WELWYN HATFIELD COUNCIL – DEVELOPMENT CONTROL
DELEGATED REPORT

APPLICATION No:	S6/2010/0659/LU
------------------------	------------------------

DESCRIPTION OF PROPOSAL:

The proposal incorporates alterations and additions to the roof including two new dormers one either side of the dwellinghouse. The main roof of the dwellinghouse is also proposed to extend at the rear by 4.2 metres from the ridgeline to form a gable demolishing the existing rear dormer and placing a Juliette balcony on the rear elevation of the new roof.

DRAWING No: 320/40 (A2)  
SCALE: 1 TO 50  
DATE: 11/4/2010

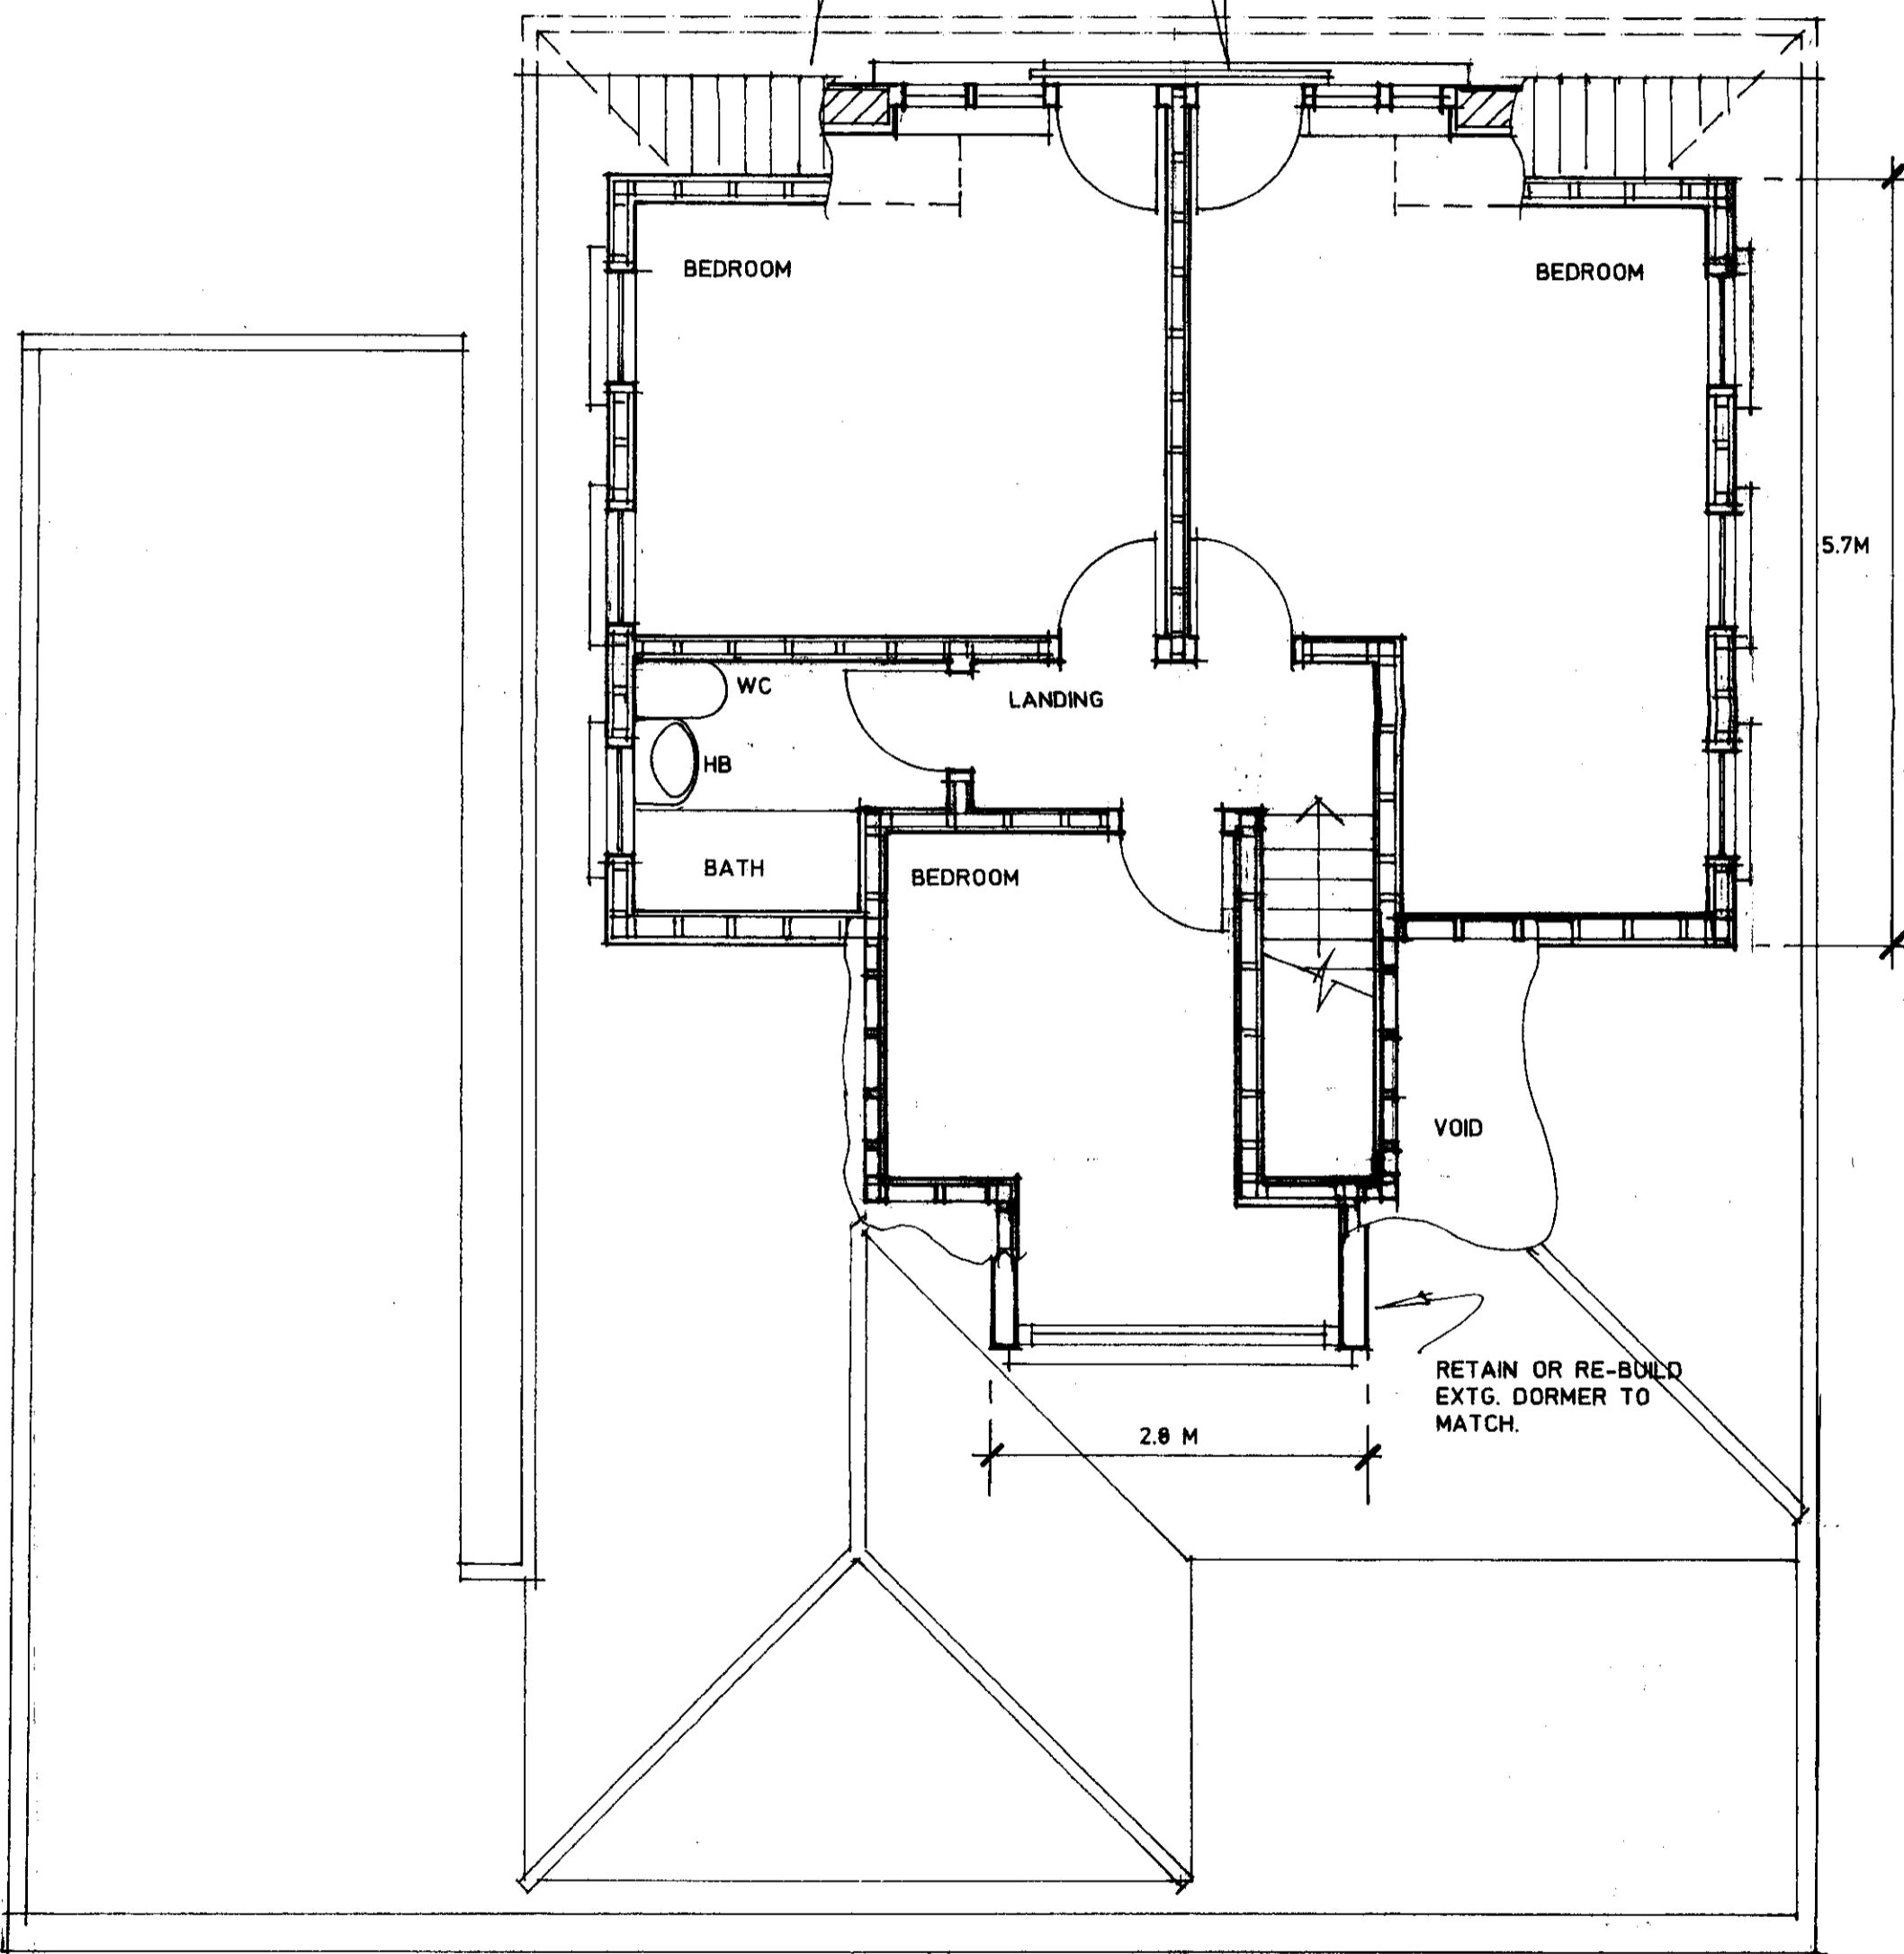
The proposal does incorporate a 'Juliette' balcony, within the roofscape to the rear of the property, with doors to open inward and toughened glass guarding to prevent access to the flat roof. 'Juliette' balconies are generally considered permitted development provided there is no platform and therefore no external access. The proposal is considered to comply with Class B (d) (i).

The application drawings do not show that the windows within the proposed dormers will be obscure glazed and non opening below 1.7 metres. However this is a condition attached and applicable to any approval and must be complied with in order to be lawful.
